Subject: Rezoning Petition Review

Date of Review: June 24, 2022 (**Revised July 20, 2022**)

Rezoning Petition #: 22-018

Location of Property: Approximately 72.20 acres located south of Johnston Oehler Rd, east of Prosperity Church Rd and west of Mallard Creek Rd.

JOB NO.
50424
SHEET NO.
RZ-1.0

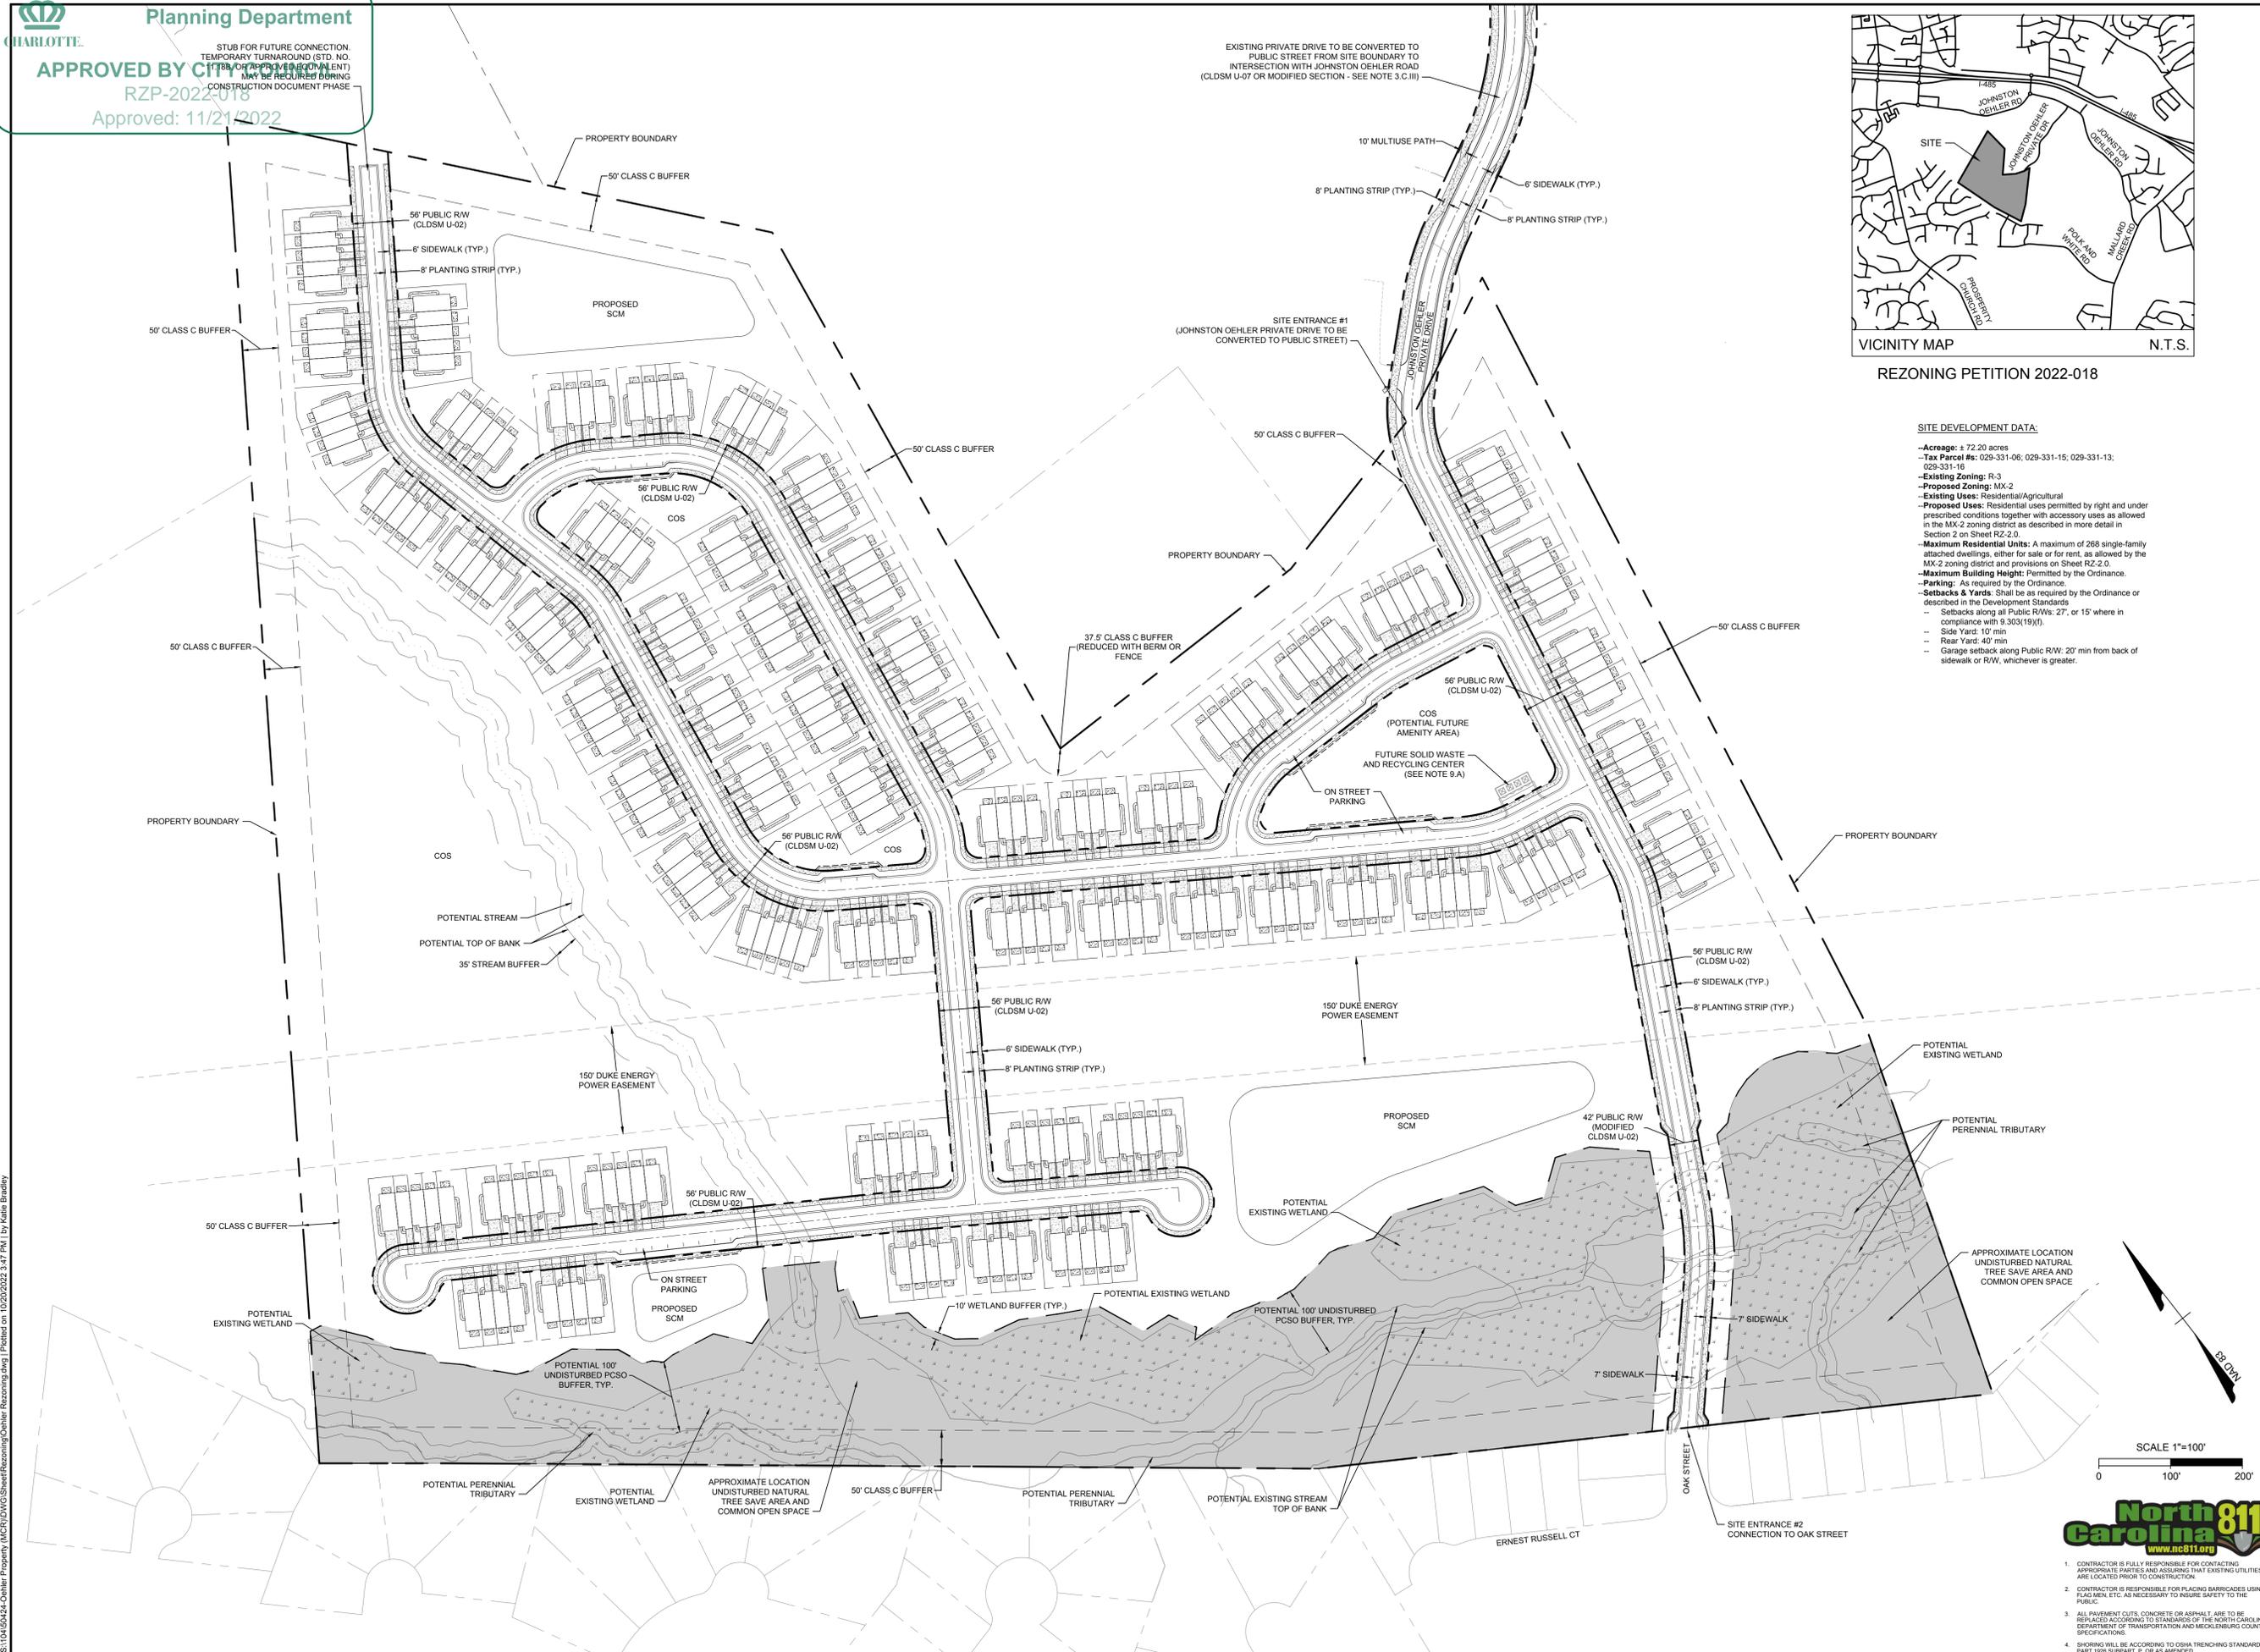
Concerning Storm Water: City of Charlotte GIS data indicates a 100-ft Undisturbed PCSO buffer across the site. Please show and label *Potential 100-ft Undisturbed PCSO Buffer* on the site plan. Any increase of impervious area within such buffers may not be allowed and is not approved with the rezoning process. Stream Delineation Reports are subject to review and approval by Charlotte Storm Water Services. Please include the following note under Environmental Features: *“Development within any SWIM/PCSO Buffer shall be coordinated with and subject to approval by Charlotte-Mecklenburg Storm Water Services and mitigated if required by City ordinance. Petitioner acknowledges intermittent/perennial stream delineation reports are subject to review and approval upon submission of development plans for permitting and are not approved with rezoning decisions.”*
